re: Planning Applications Received by Welwyn Hatfield Council

Application No.	Description and Location	Applicant/Agent
S6/2014/1321/OR	Prior approval for the change of use of office building (use class B1a) to 4 residential flats (use class C3). Willow House 16-18 Salisbury Square Hatfield AL9 5BE	Mr T Waller JB Planning Associates Limited Chells Manor Chells Lane Stevenage SG2 7AA

The Welwyn Hatfield Access Group has reviewed all the data submitted with this application via Welwyn Hatfield Borough Council's website. We would like to tender the following comments:

Drg.No: AT376-02

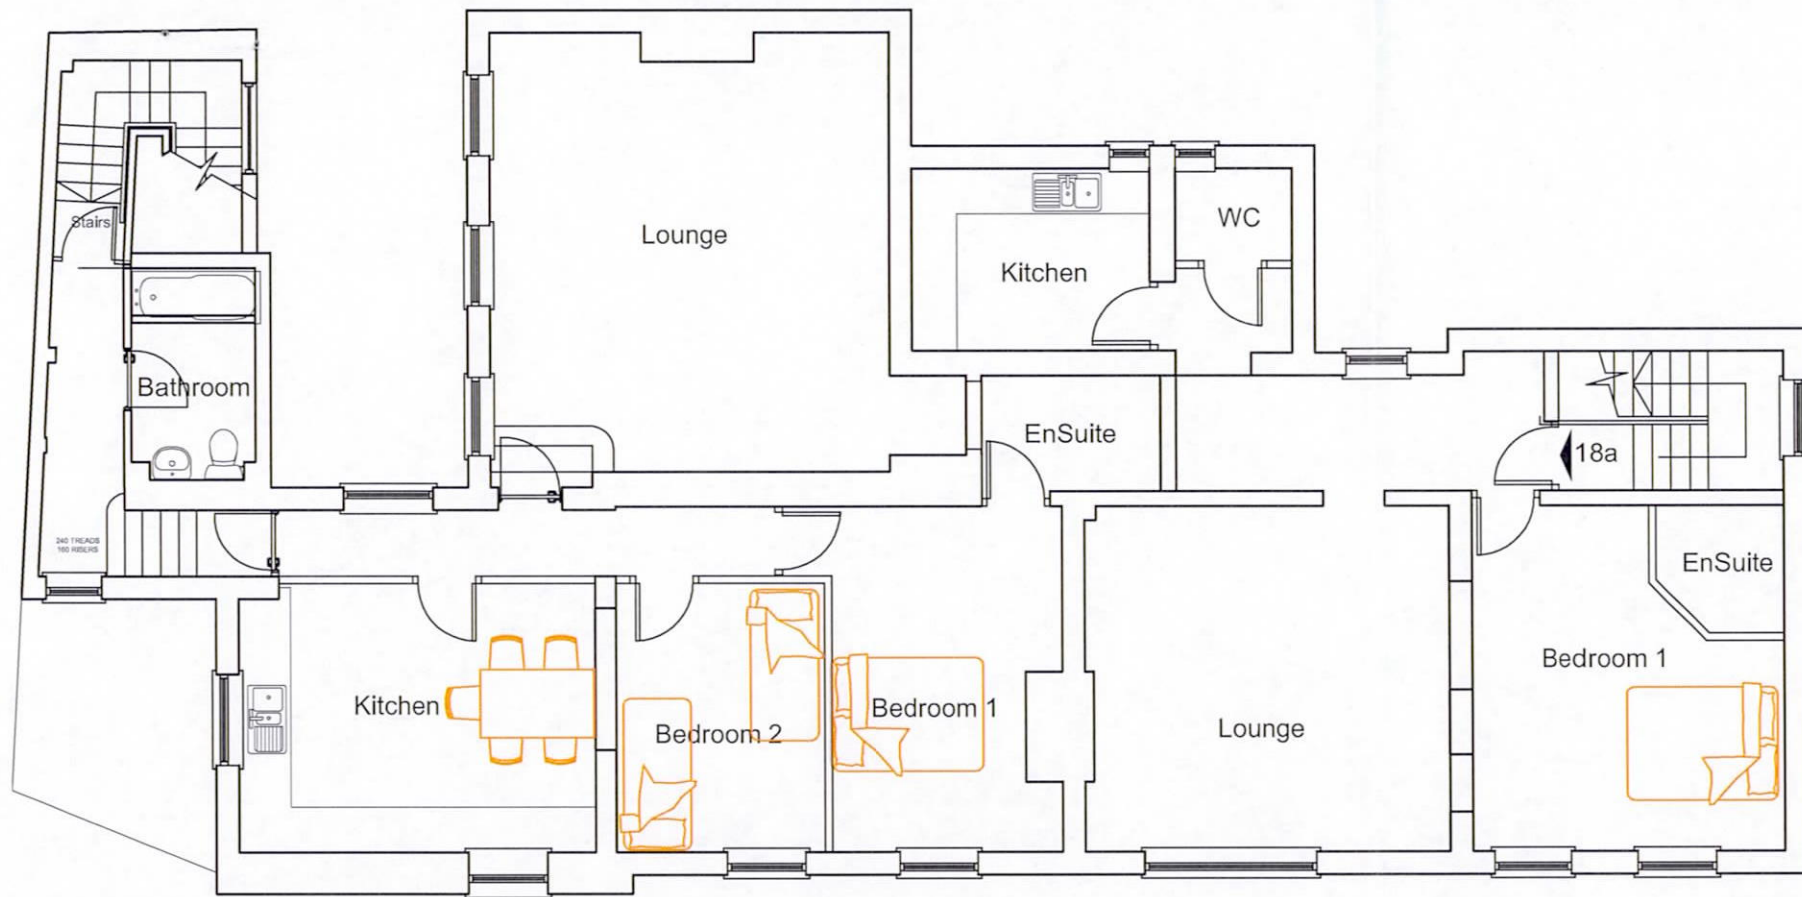
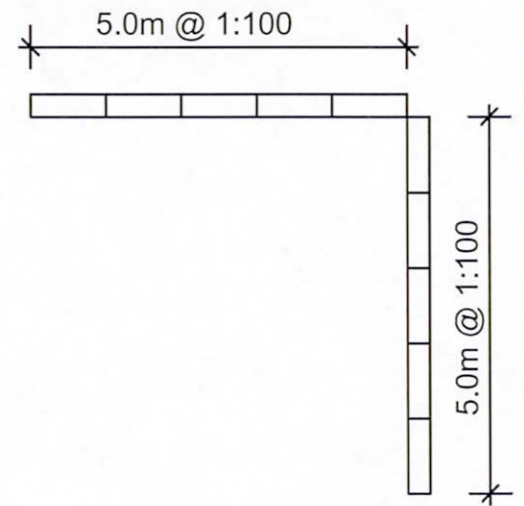
This drawing identifies the Proposed Ground Floor and First Floor Plans. We note that the proposed development provides for a total of 2 x 2 bedrooms dwellings and 2 x 1 bedroom dwellings, one of each on both floors.

The ground floor provides 2 shared entrances - 1 of which is serviced by inward opening double doors and the other serviced by a single inward opening door. Could you please confirm the dimensions of these doors (both double and single), their opening forces together with details of the door fittings/furniture.

We note there is no lift linking the floors and ask you to confirm that the 2 stairwells meet Part M guidelines.
